Our ref: DOC22/747958
Your ref: SSD-36778089

Subject: Advice on EIS - Ryde Hospital Redevelopment (SSD-36778089) (City of Ryde)

The biodiversity development assessment report (BDAR) prepared by Ecological Australia, dated 22 July 2022 has been reviewed and EHG raises the following comments in relation to biodiversity impacts.

Drawing Number: RHR-ARC-DR-SSDA_S1_003 Rev: 6

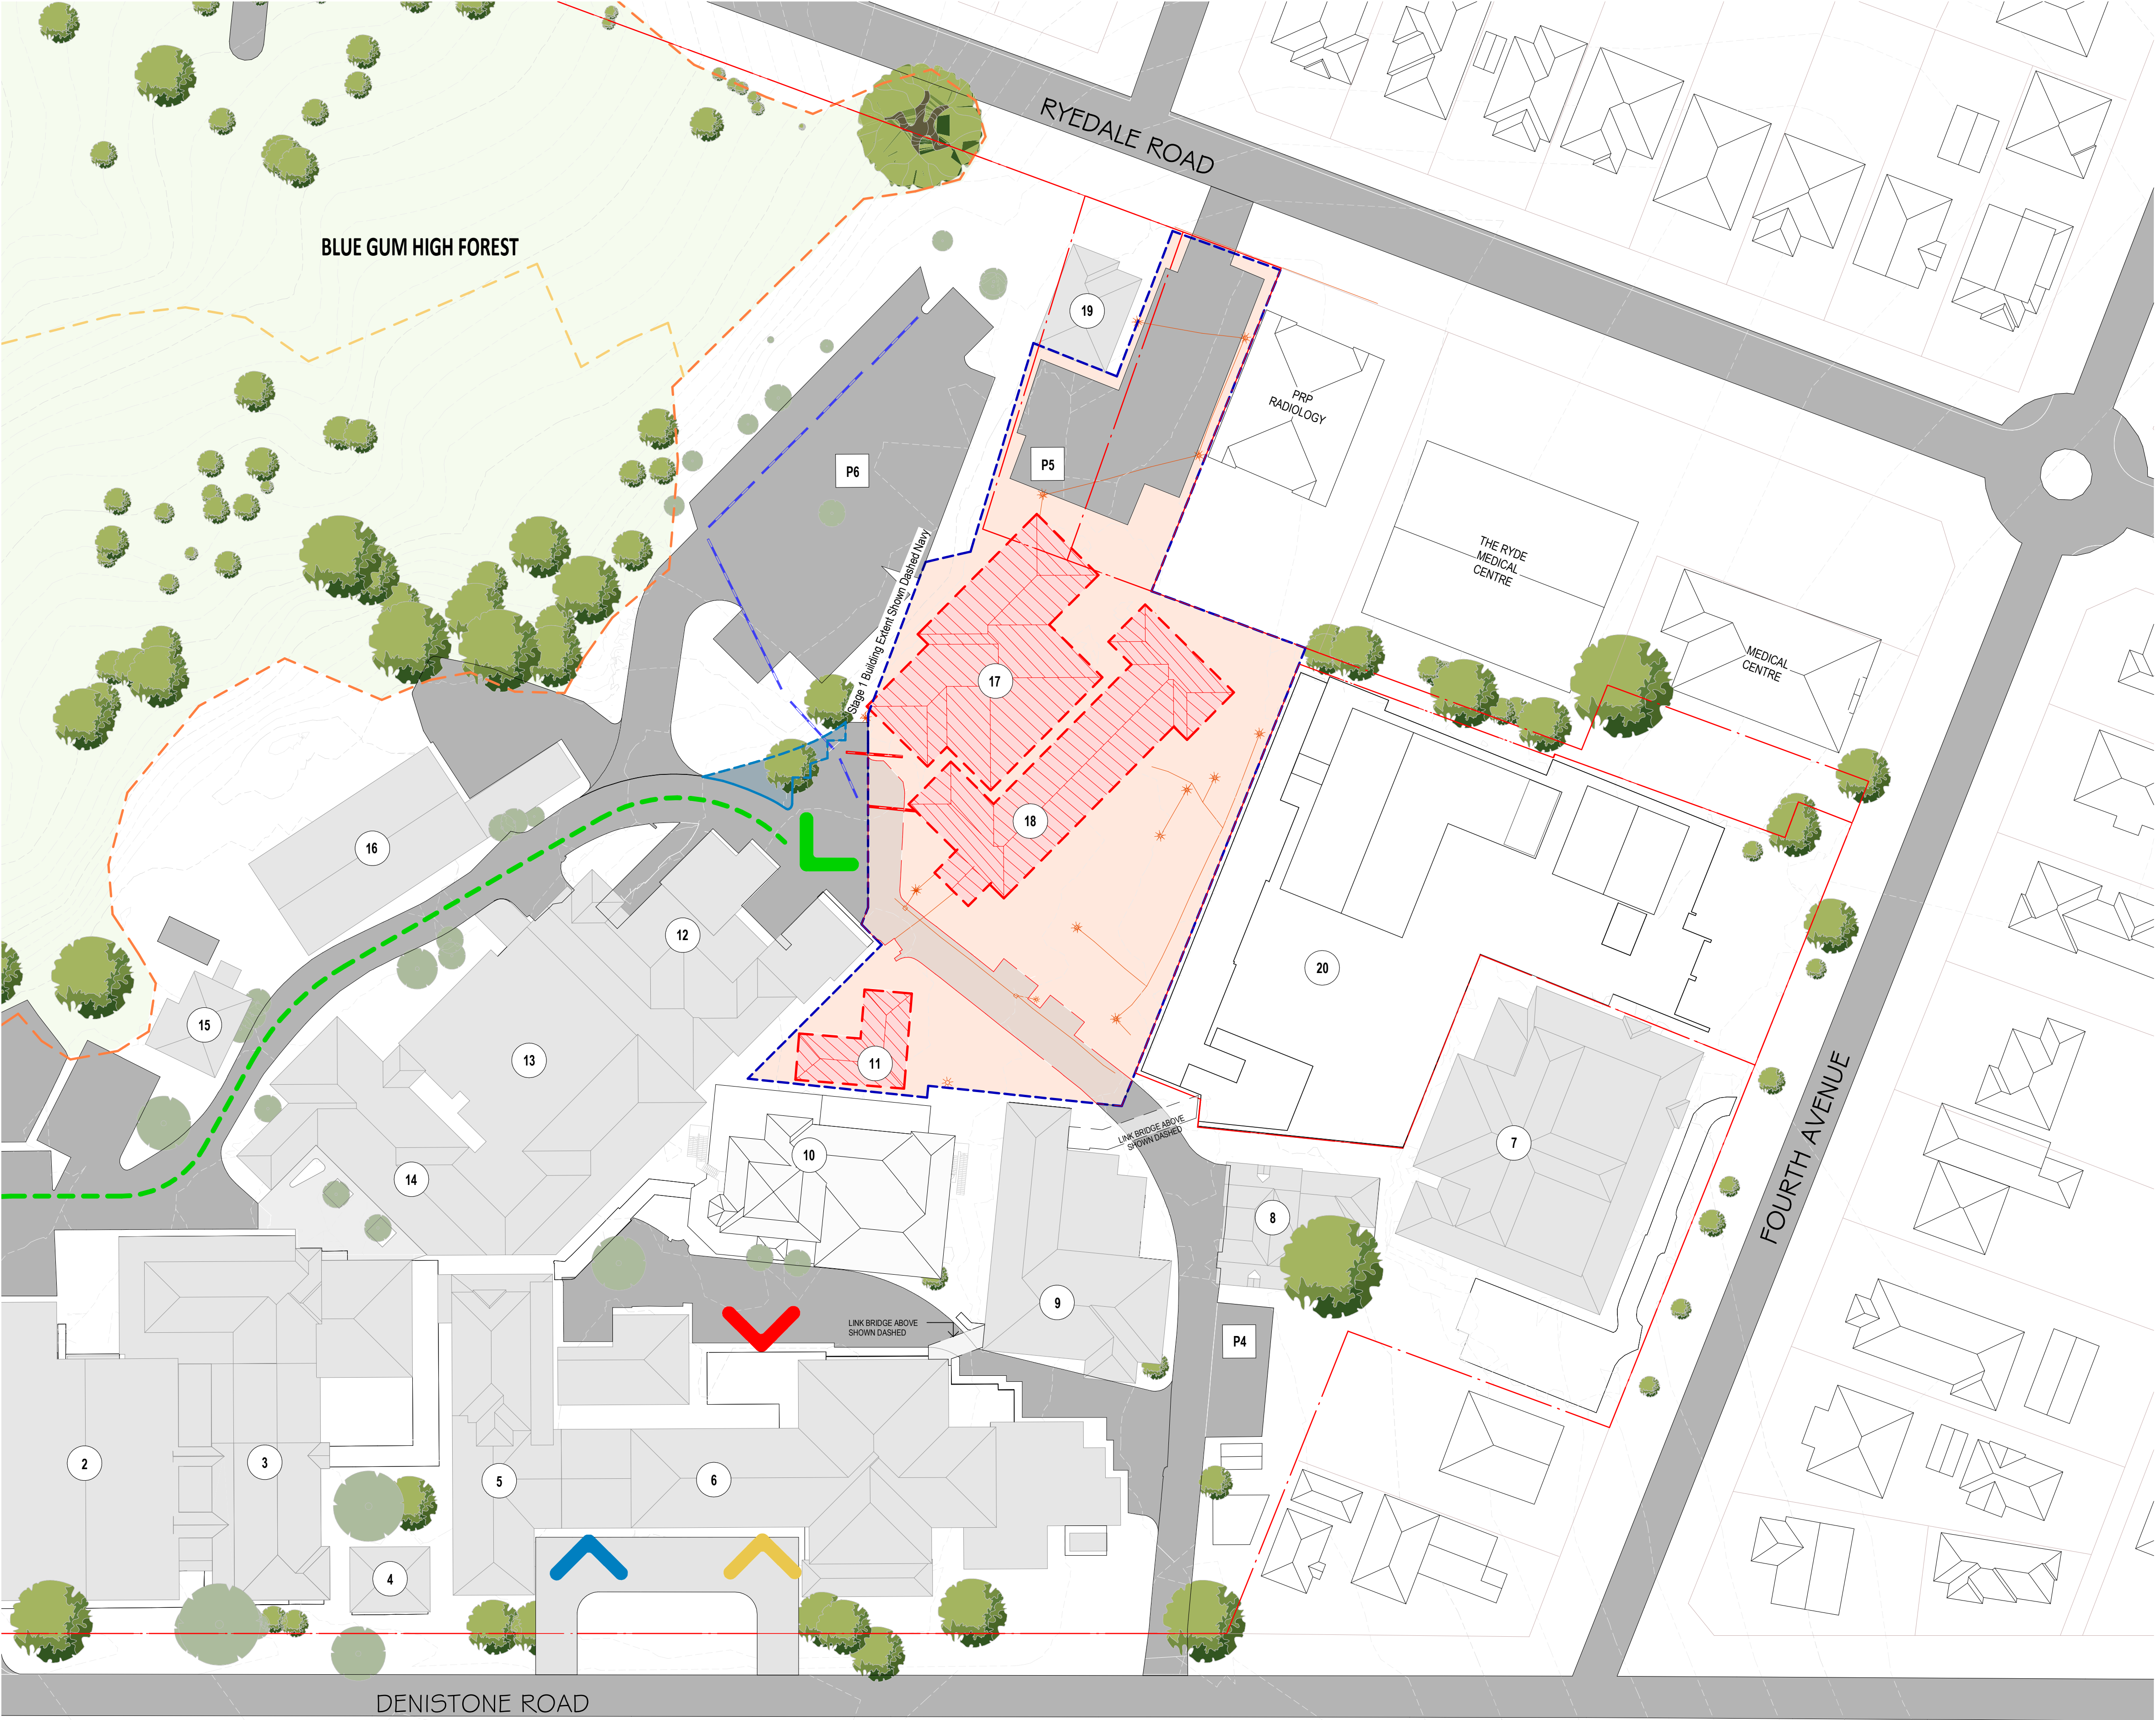
- The EIS notes that a temporary decant building is to be located along the northern boundary of the site however stage 1 plans show this structure to be located along the edge of BGHF. It is unclear if there will be impacts to any BGHF trees associated with the construction of this building. Clarification is also sought if the temporary building will require an APZ beyond that identified for the concept proposal.

- The stage one plans show temporary at grade parking structures adjacent to buildings 1 and 16. Civil works associated with the construction of these structures have the potential to impact upon existing BGHF trees. Any trees adjacent to these proposed works should be identified in the AIA and any impacts or tree protection requirements should be discussed.
